Application No. AS/8/12

Anita Gardner**From:** Anita Gardner**Sent:** 15 March 2012 09:06**To:** 'Andrew Fuller'**Subject:** AB/8/12 - Erection of one dwelling - Land adjoining 84 Maltravers Street, Arundel

Proposal: Erection of one new dwelling
Address: Land adjacent to 84 Maltravers Street, Arundel

Elevations & Section

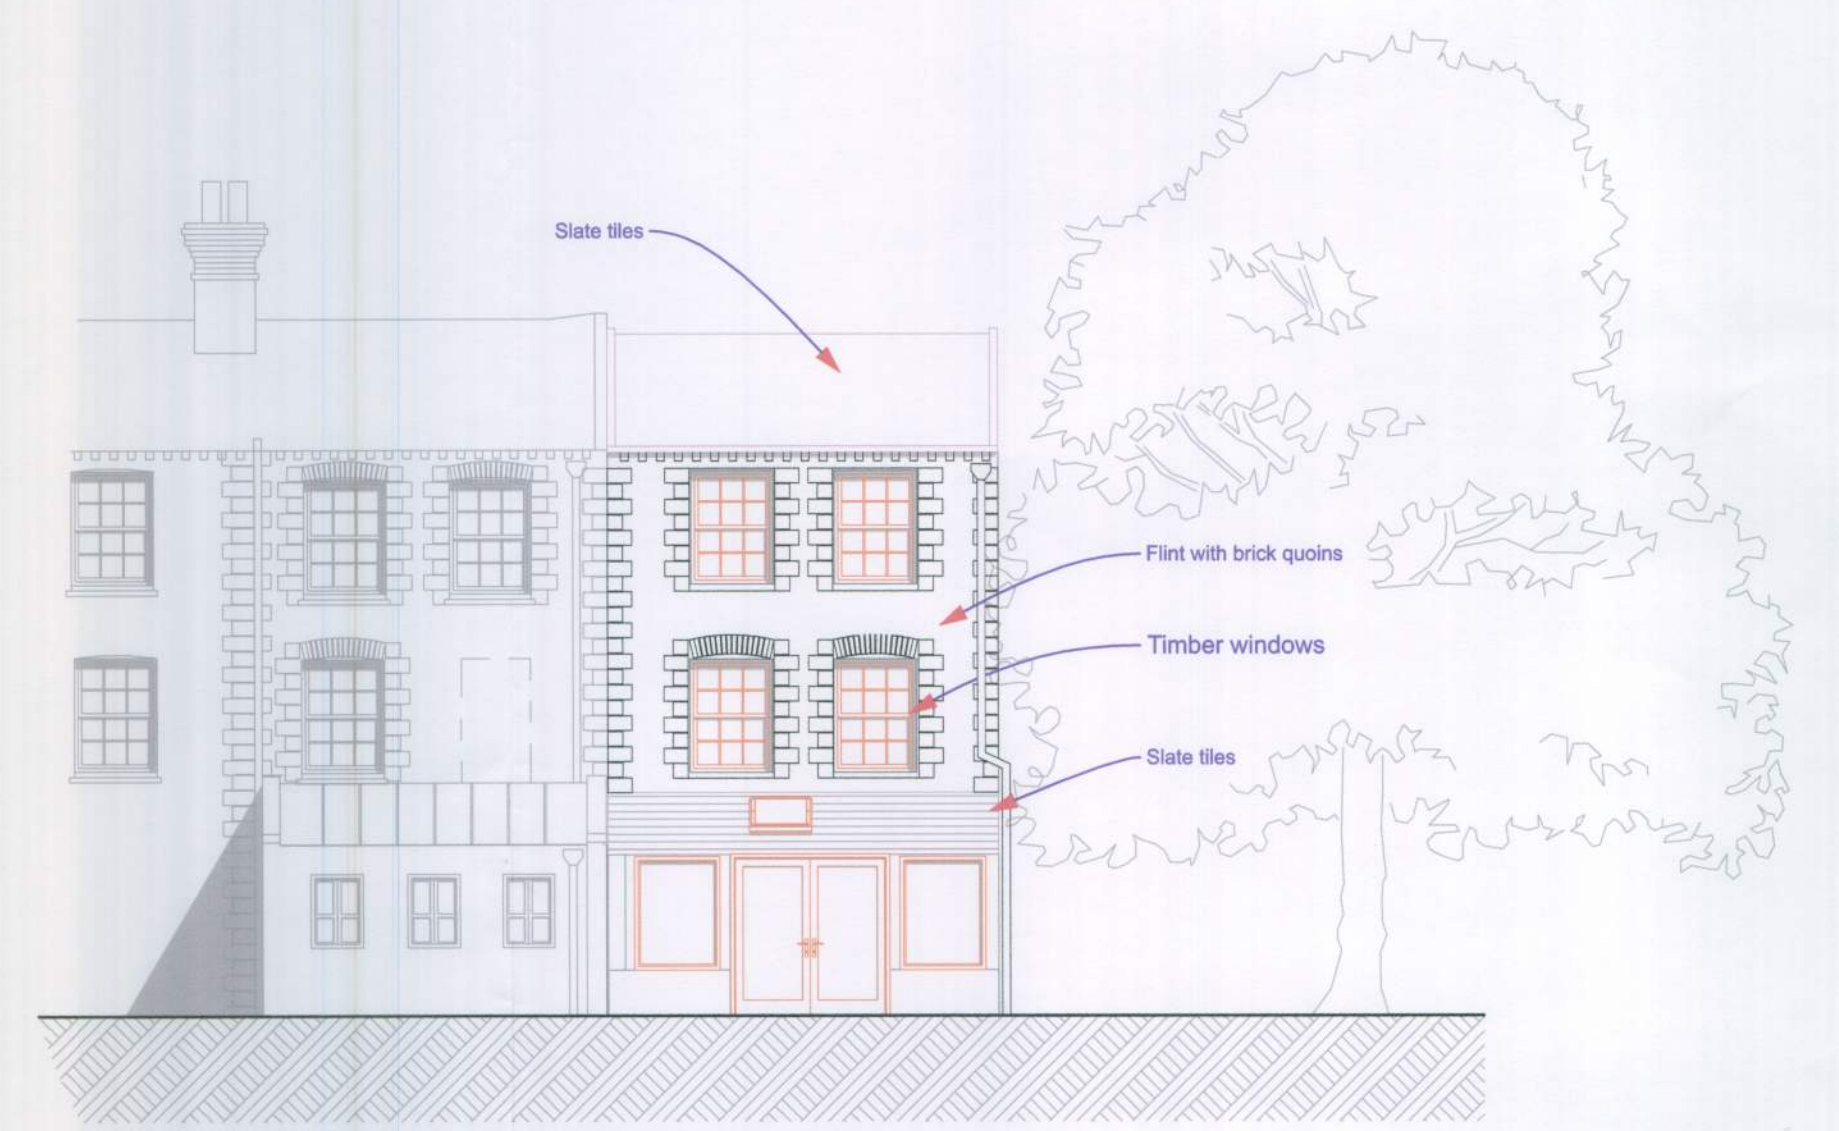
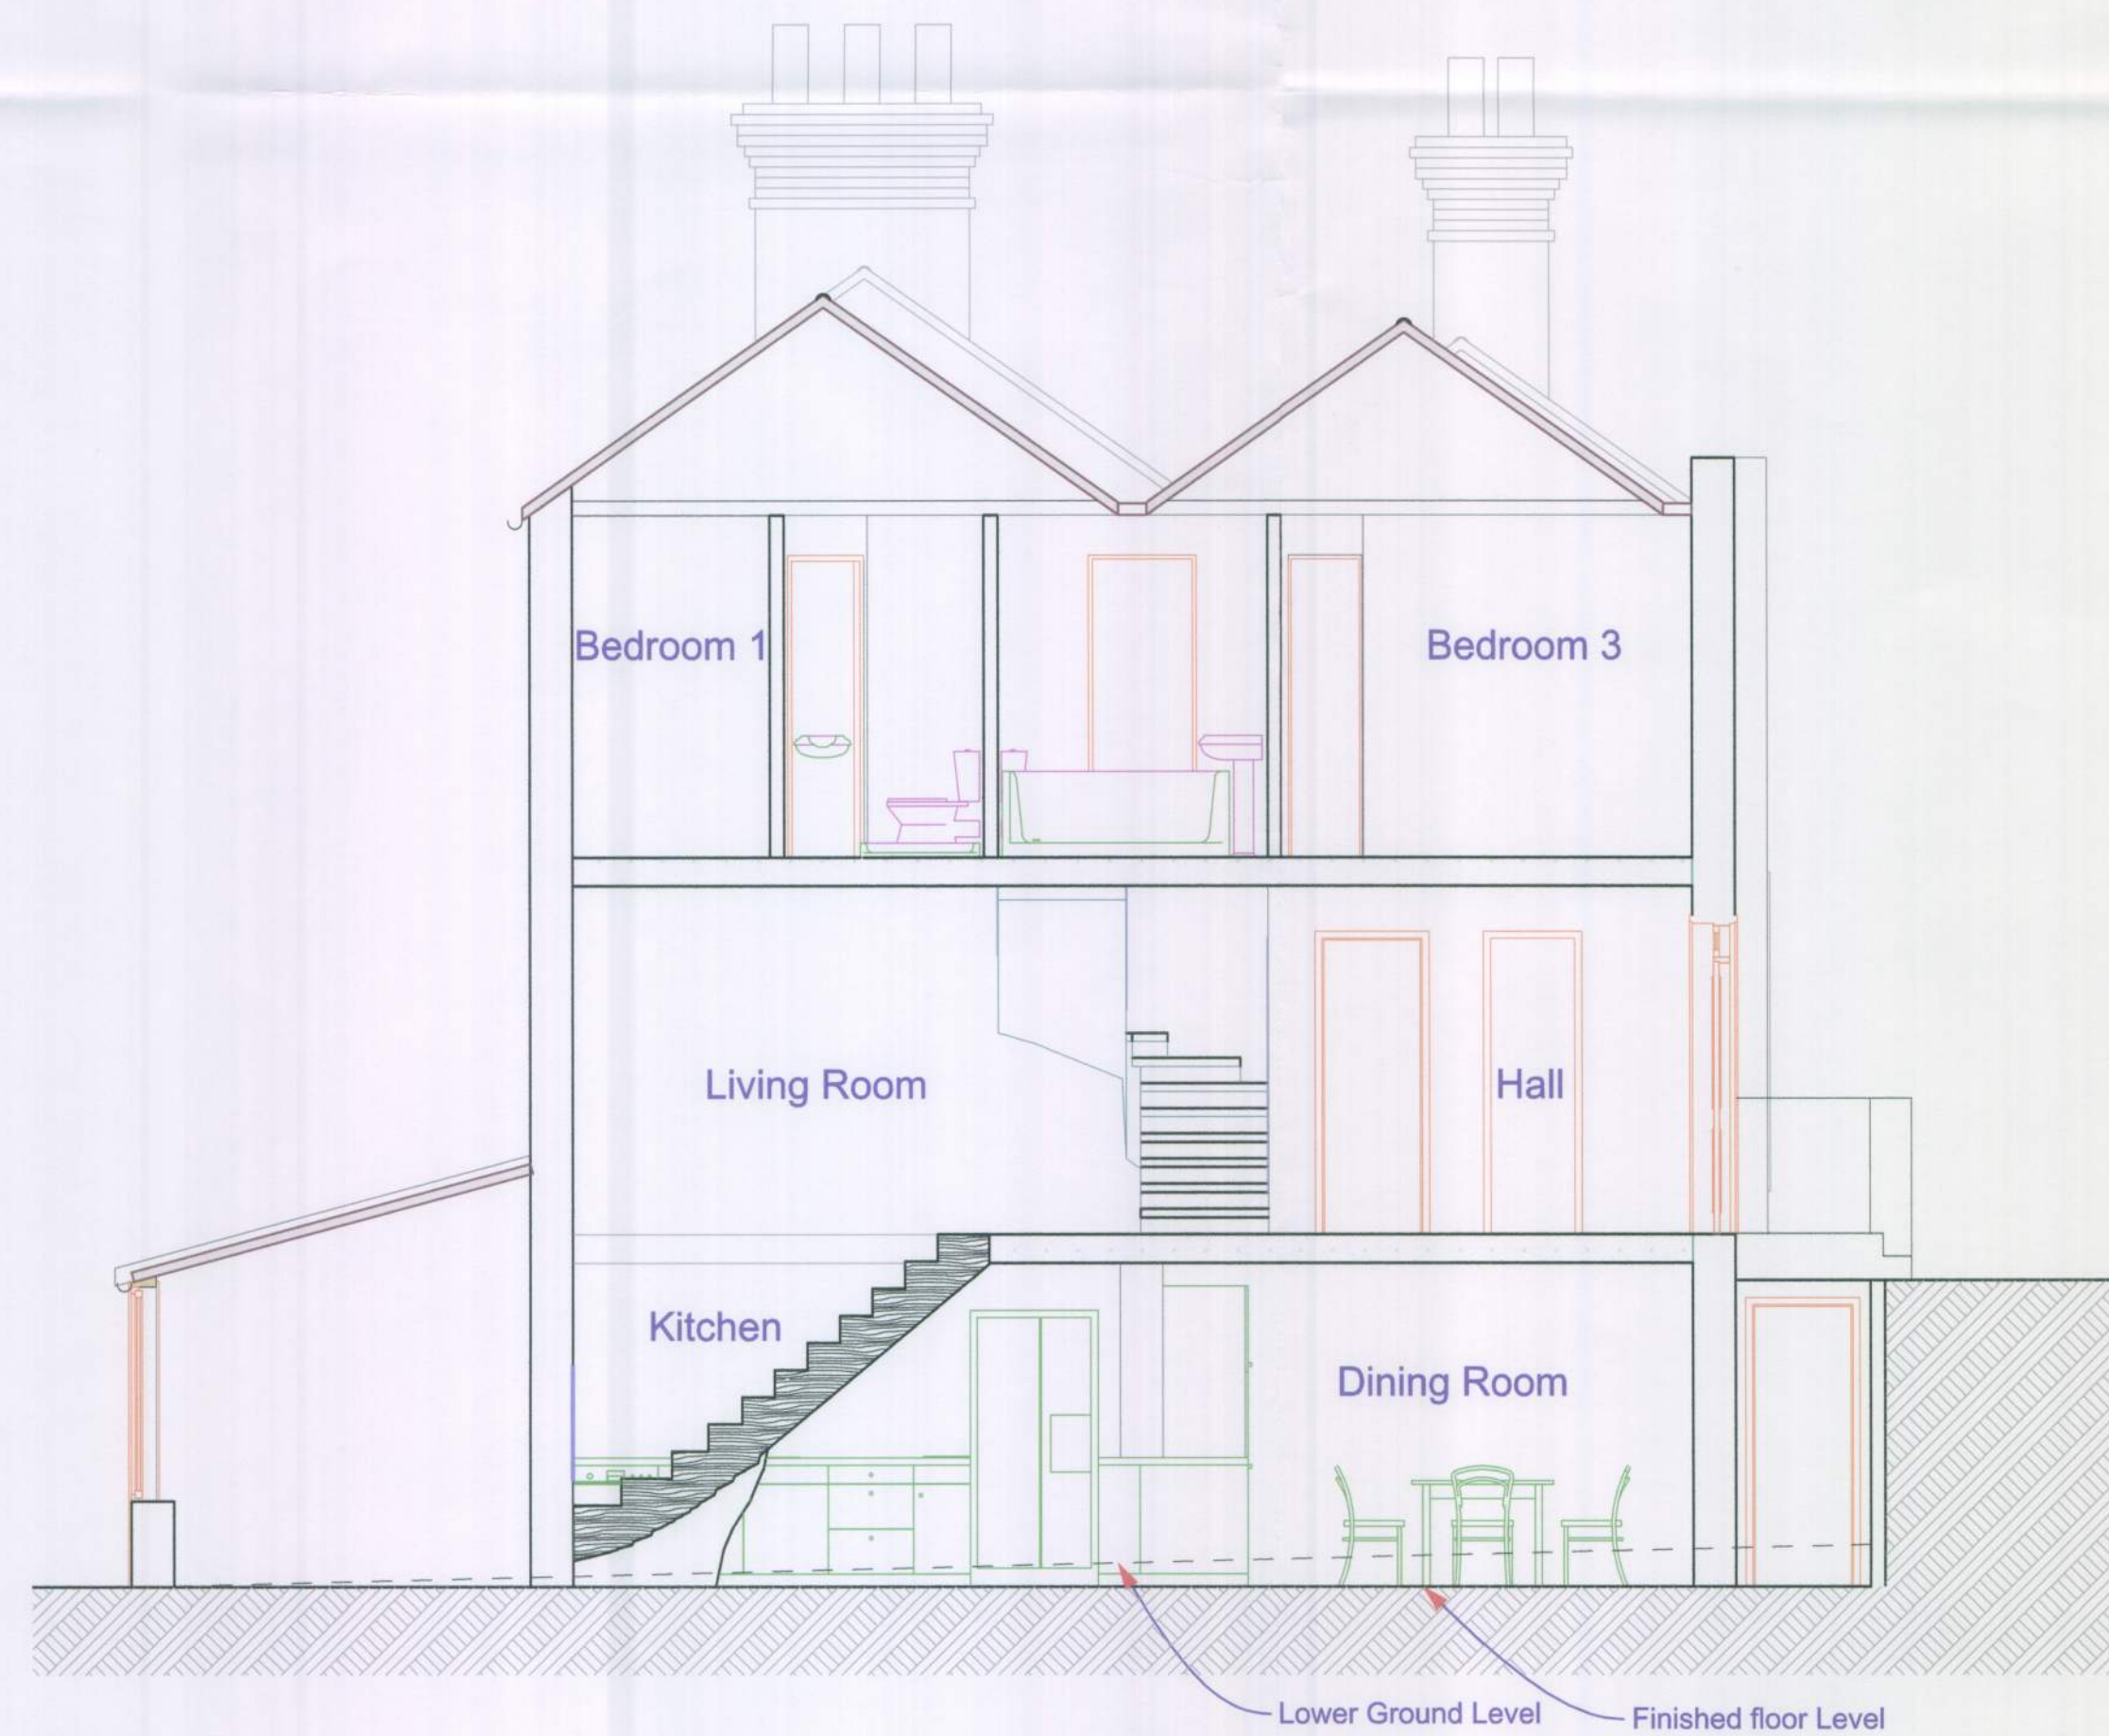
In his view the principle of a dwelling is unacceptable. He remains to be convinced that even a single storey structure can be accommodated without compromising the historic form of the terrace or the relationship of the building to the street scene and the visual permeability of the site.

¿ As the terrace is Grade II Listed and sited at the start of one of Arundel's premier streets (containing some of its most historical and architecturally interesting housing stock) to alter this with an extension would directly contravene the historic and architectural integrity of the area. ☐

¿ A new build attached to this terrace would upset the flow of the existing terrace of 6 near identical houses as the new build would make a seventh, thus odd number. ☐

¿ A new build would cover up the returning end wall which shows evidence of old subsidence repair and as such has a charm, character of its own as well as demonstrating old methods of repair. ☐

¿ The development would unnecessarily alter the existing balanced appearance of the terrace as the line of the chimneys, windows and front doors would all be unbalanced by the addition. The old perimeter wall would be changed and the vista fronting onto Maltravers Street would be changed to its detriment. ☐
